Application number: 2025/91168	
What is the application for?:	Demolition of existing garage and erection of MOT bay/service area (within a Con
Address of the site or building:	Wilton Mills, 586, Bradford Road, Batley, WF17 8LP
Postcode:	WF17 8LP

Type of comment: An objection	
Do you wish your comments to be published on the website anonymously?	<input type="checkbox"/> Yes
<p>I have submitted a letter to the casde officer letter reference 2025-62-91168-E 6th July pdf version outlining my objection. I have pasted the first part of the text of the letter here as the system does not allow me to attach a file and is words limited. I will attached the remainder on a separate comment.</p> <p>Dear Sirs,</p> <p>Re: Planning Permission 2025/62/91168/E Demolition of existing garage and erection of MOT bay/service area (within a conservation area). Objection to Planning Submission</p> <p>I am writing as the owner and resident of</p> <p>strongly object to the current planning application on a number of grounds which are explained herein.</p> <p>Noting that this is a retrospective planning application to a previously approved application 2022/62/933660/E, I also continue to raise the serious c

PROPOSED SOUTH EAST ELEVATION, SCALE 1:100

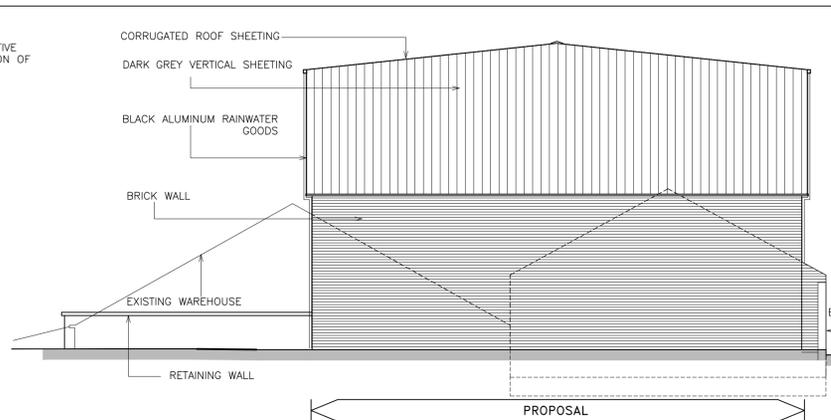
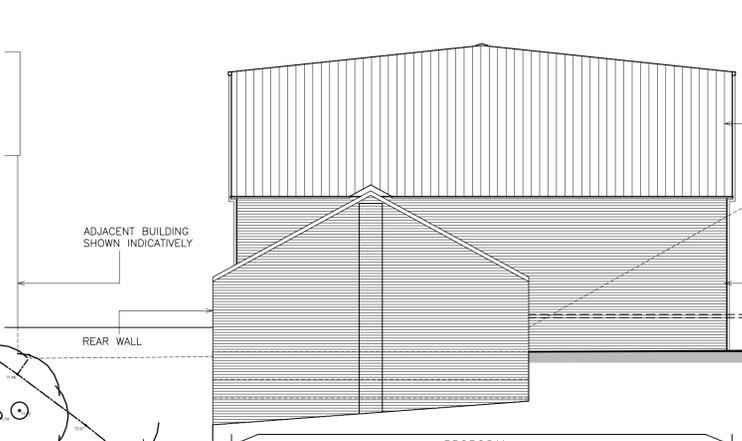
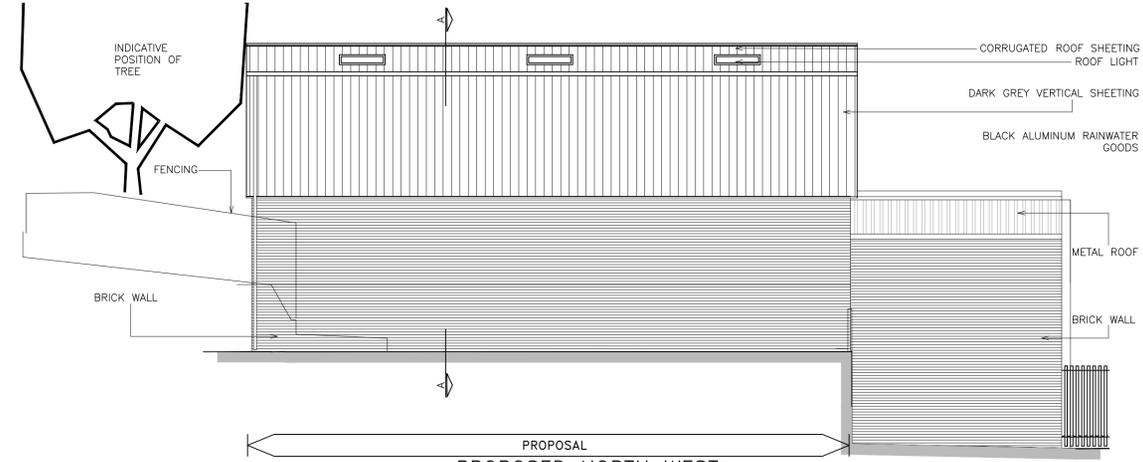
- Approved height of structure under application 2022/93360 is 6,900mm (including parapet. Submitted height of structure under application 2025/91168 is 8,825mm. The current construction is almost 2 metres higher than the council approved.

- The approved structure under application 2022/93360 was a cladded steel frame with sloping roof with Parapet to the viewing onlookers. The constructed structure is a portal steel frame with pitched roof showing rooflights to onlookers with no parapet.

- The design of the current structure is different to that previously approved. The new structure of a portal frame with pitched roof is totally different to the previous structure of a flatter roof surrounded by a parapet. This means the higher structure as constructed will expose the roof lights to my view and that of other neighbouring properties.

PROPOSED BLOCK PLAN (SHOWING INDICATIVE DRAINAGE PLAN), 1:1200

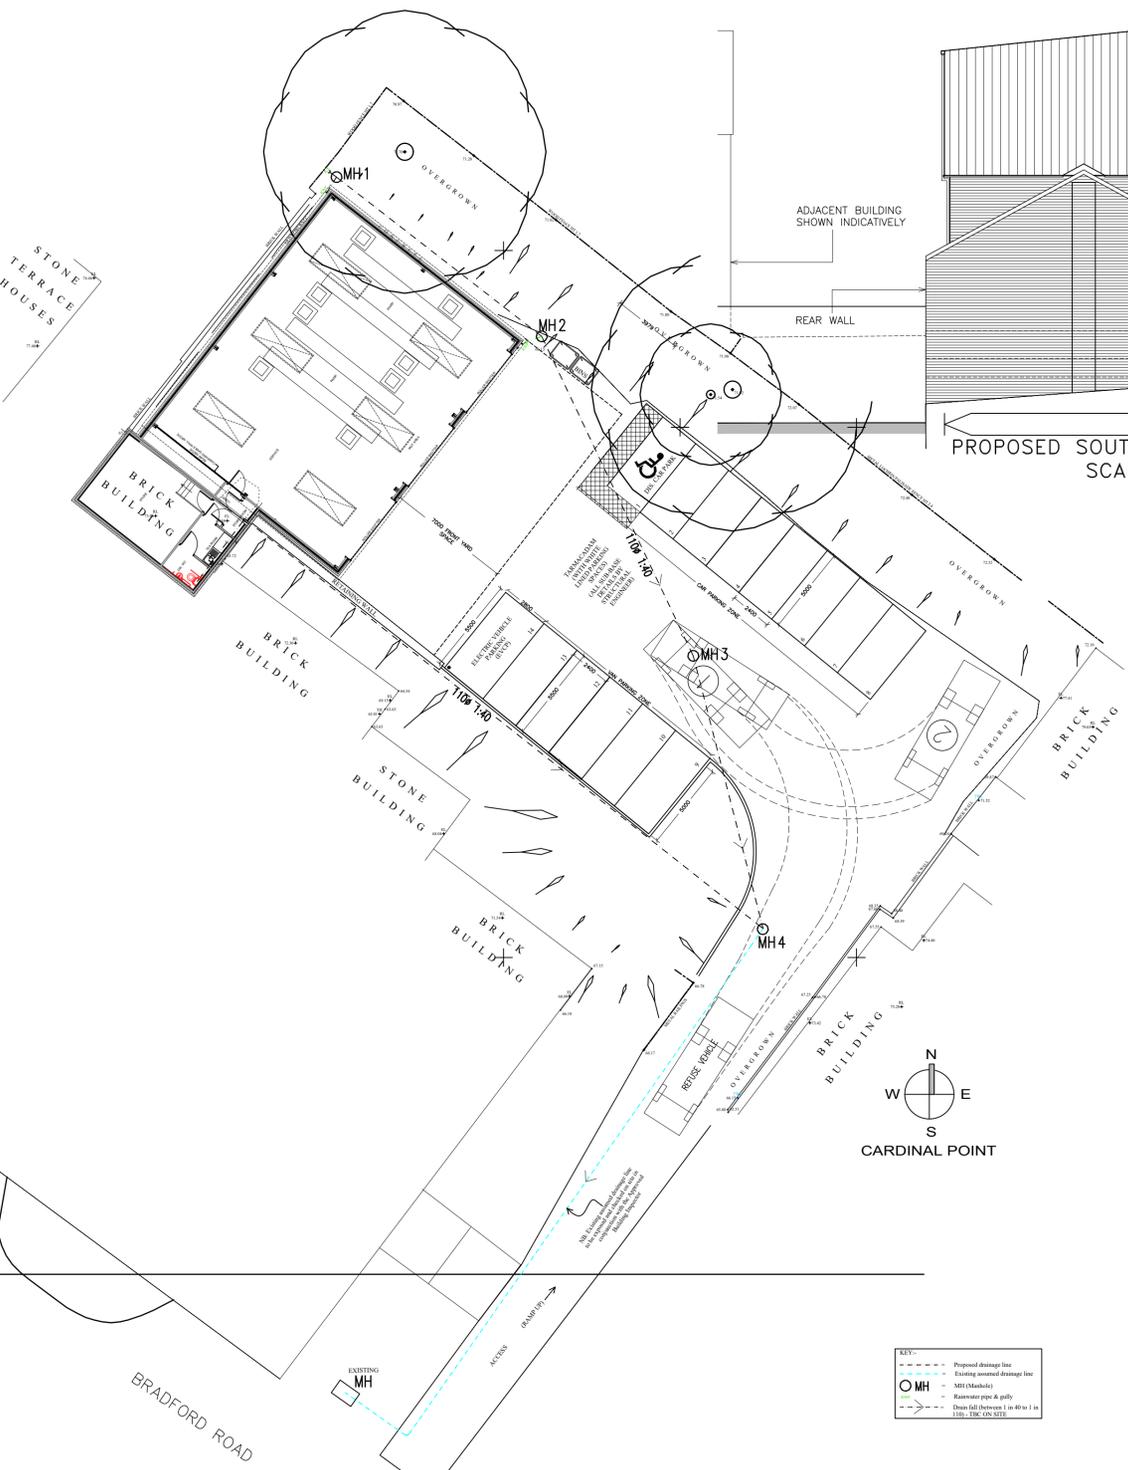
- Approved footprint under application 2022/93360 is 16,513 x 10,952mm. Submitted footprint under application 2025/91168 is 17,025 x 14,001mm. The constructed footprint is bigger than the approval granted.
